Application for Removal or Variation of a Condition following Grant of Planning Permission or Listed Building Consent

Internal Alterations, Two Storey Side and Rear Extension Attic
Conversion including Dormer to Rear, and Rendering of First
Floor Front Elevation

23/00450/FHA

Change in materials new drawings below -
22011 AL (0) 110D
22011 AL (0) 111D
22011 AL (0) 120D

[PROJECT]	Alterations + Extension to 2 Ridgeway Berkhamsted
[DRAWING]	PROPOSED ATTIC + ROOF PLANS
[SCALE]	[CHECKED] 1:50 @ A1
[STATUS]	PLANNING
[NUMBER]	22011 AL (0) 111D

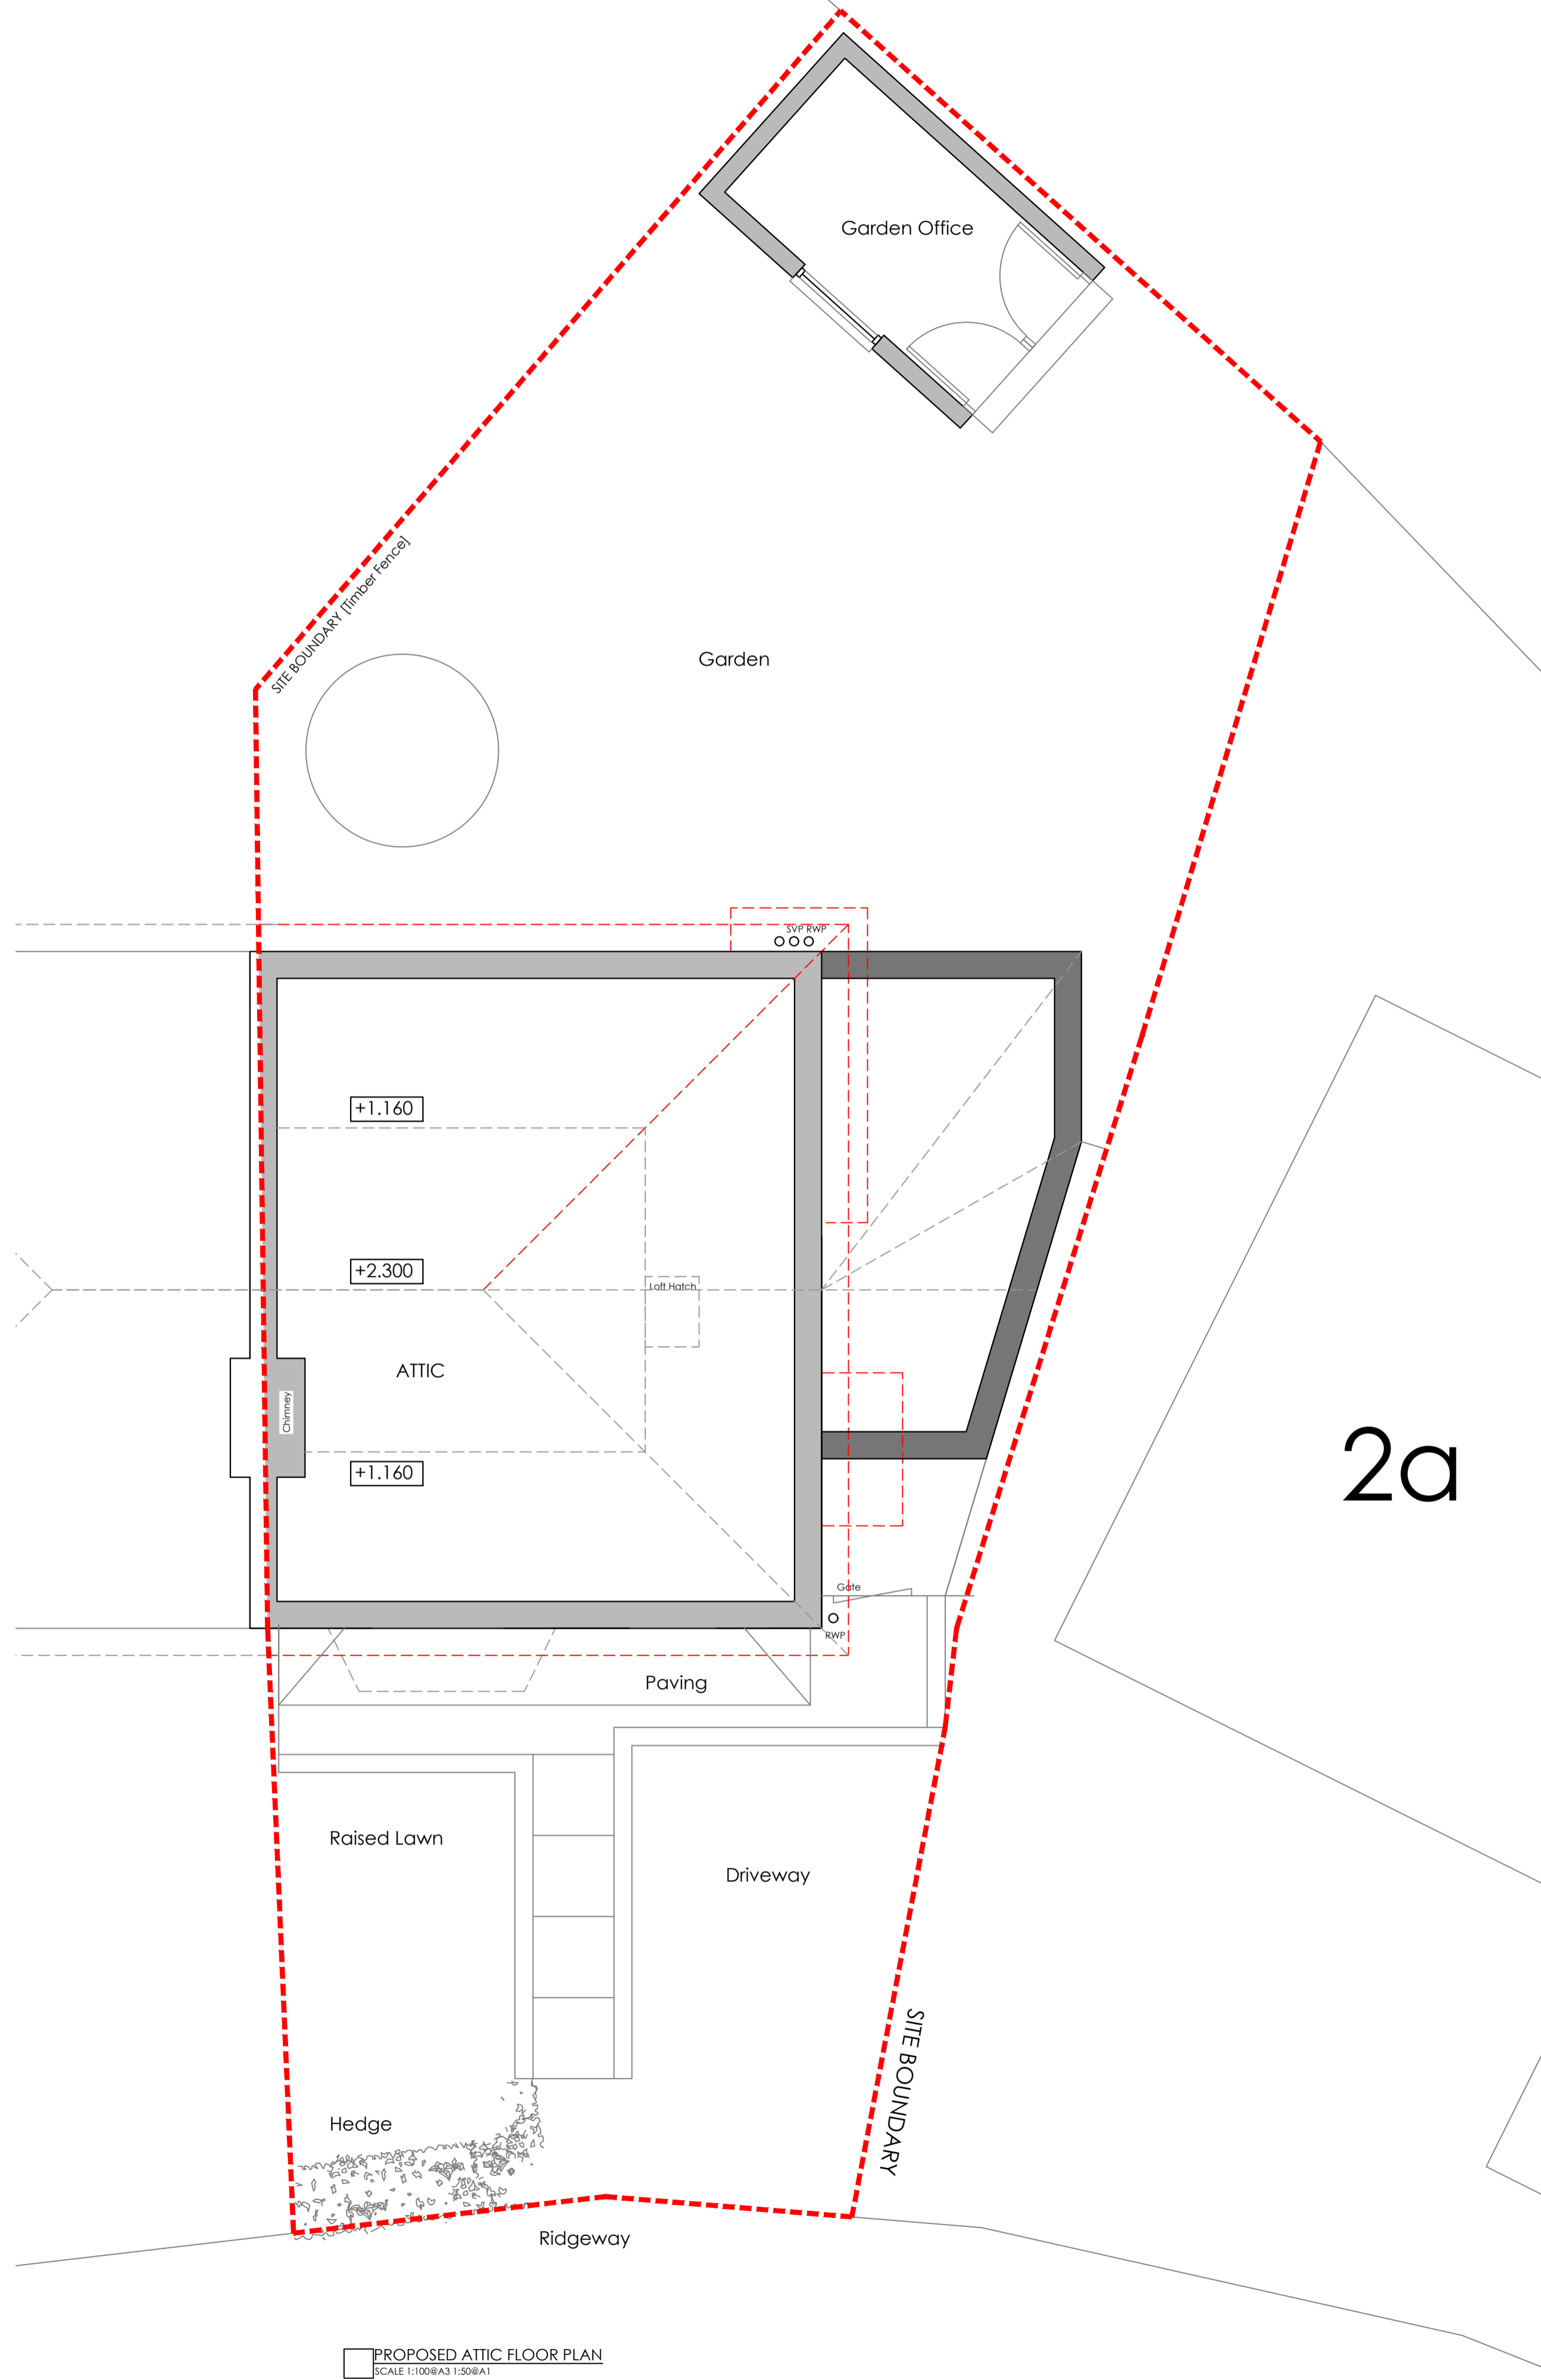
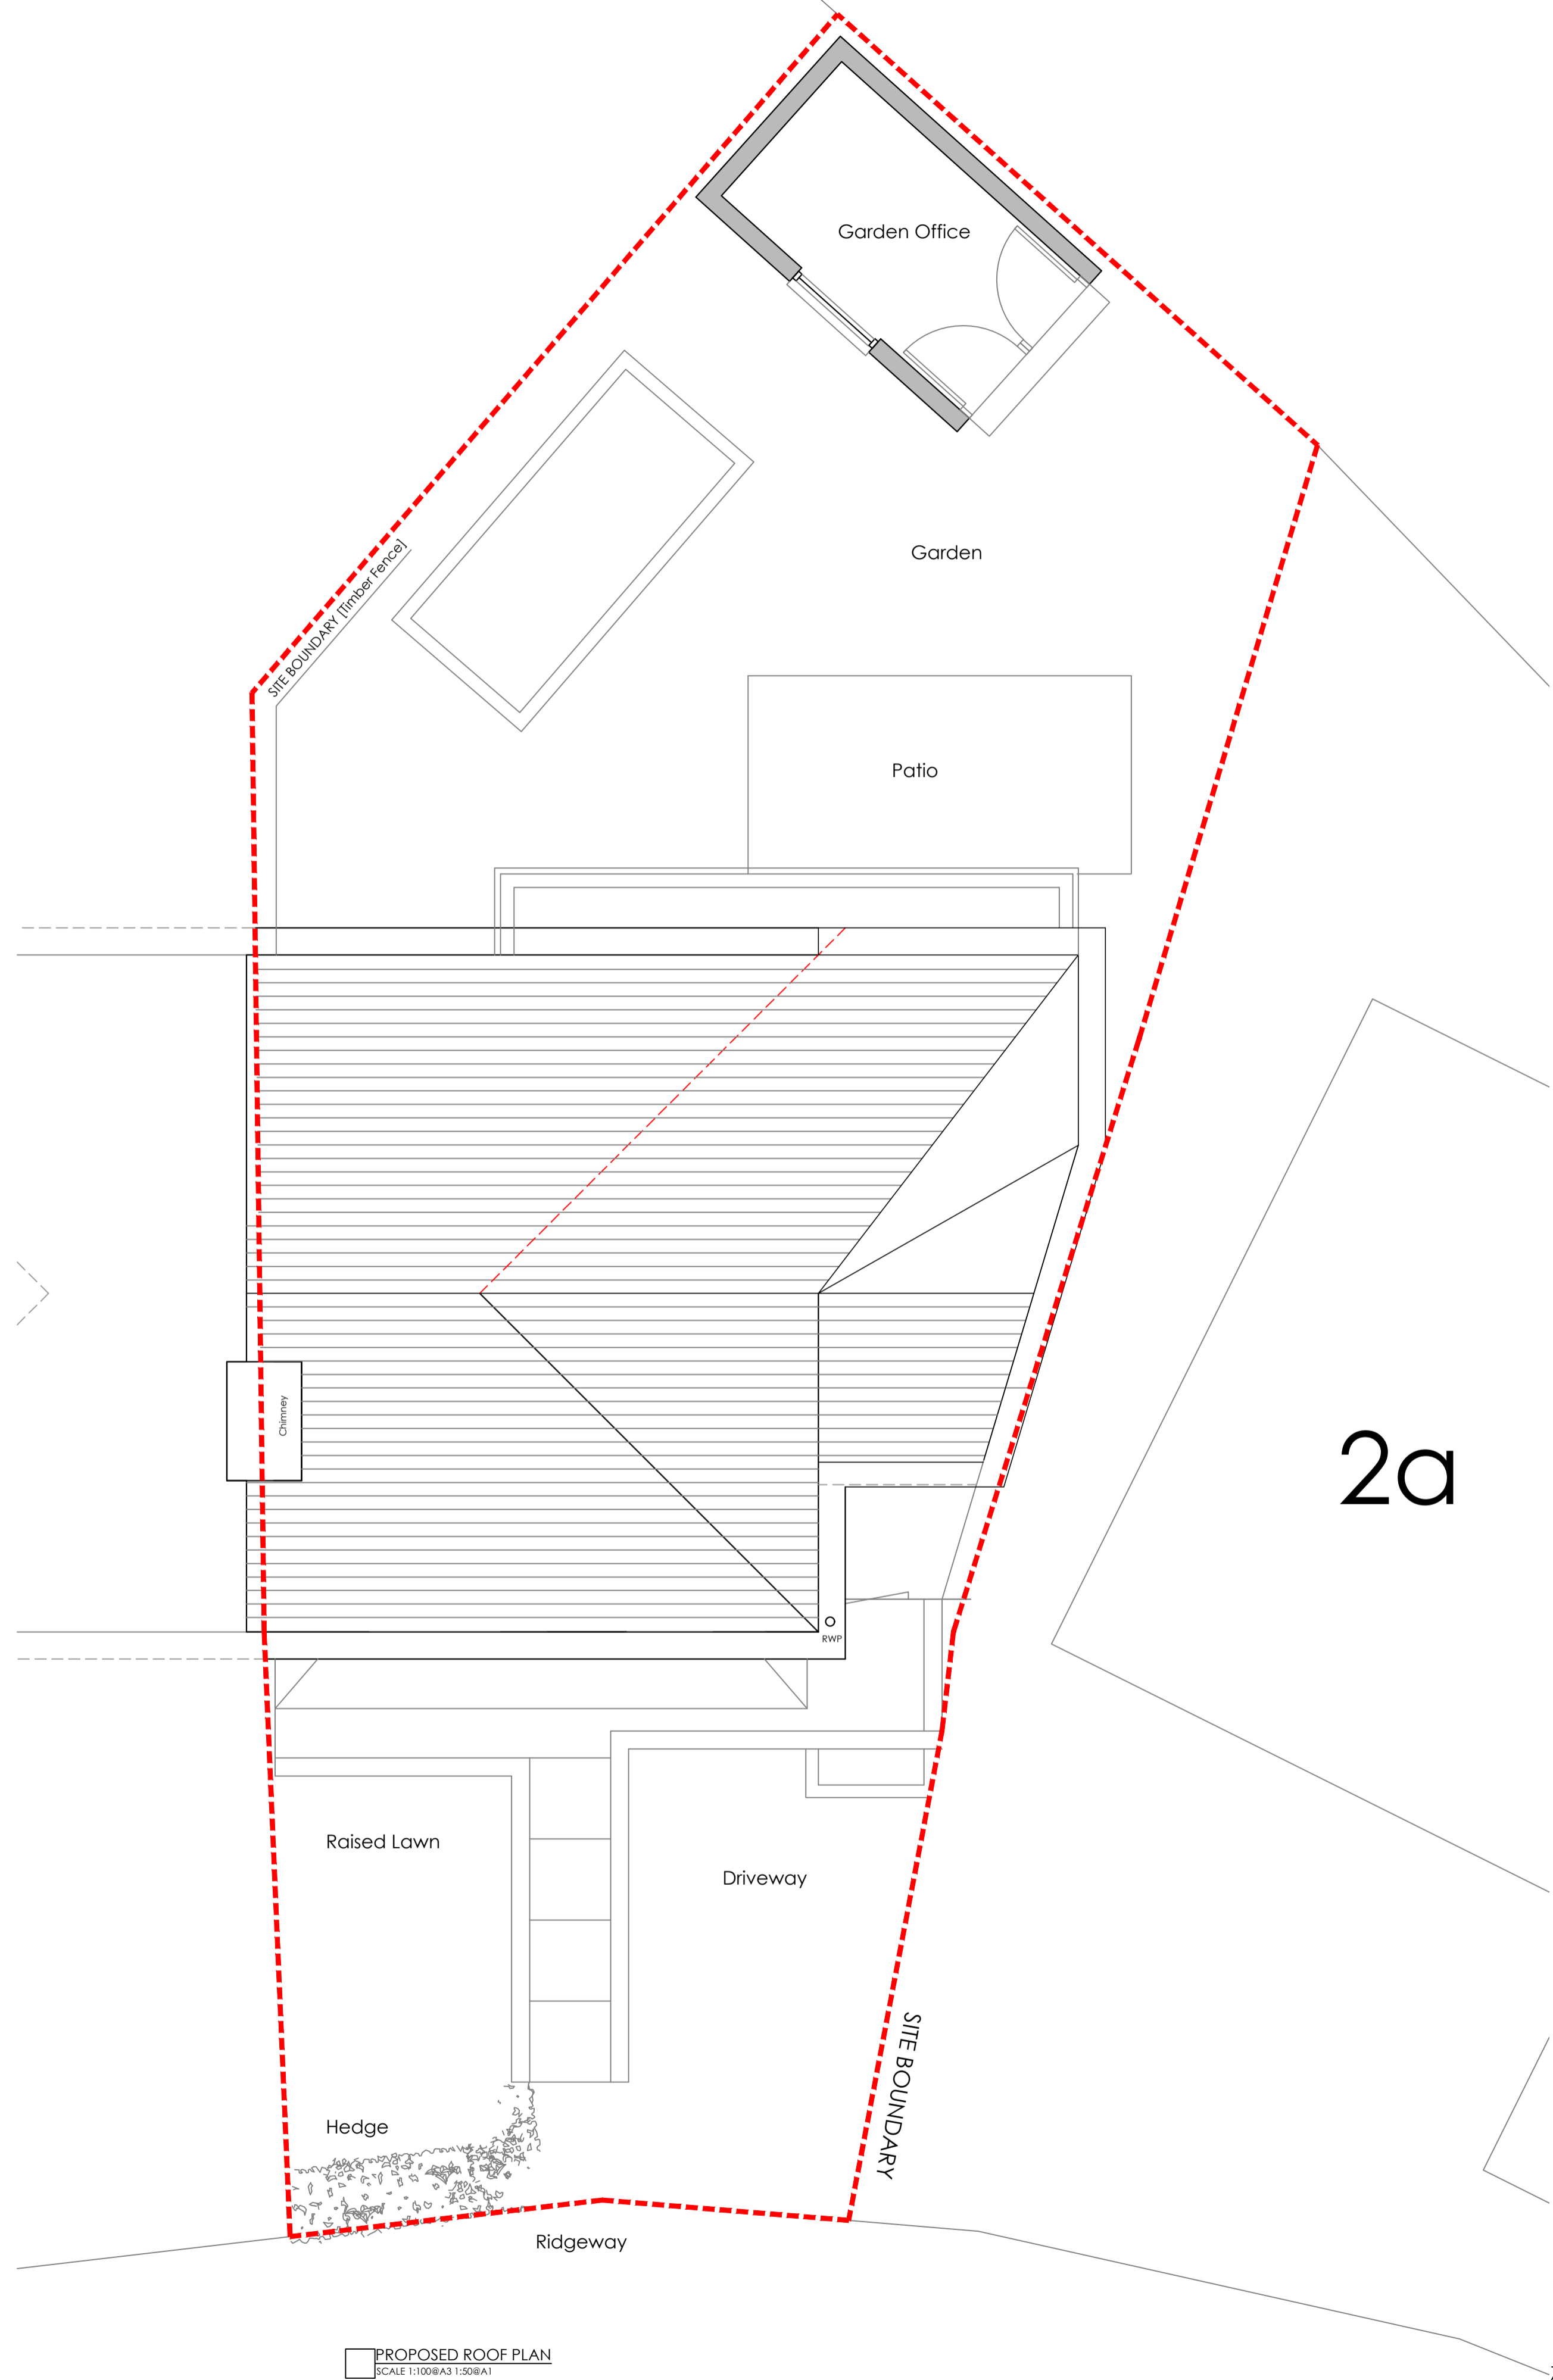
Change in Materials - omit proposed render to front / rear elevations
Omit Loft Conversion works
Omit Rear Dormer Window
Omit Velux Windows
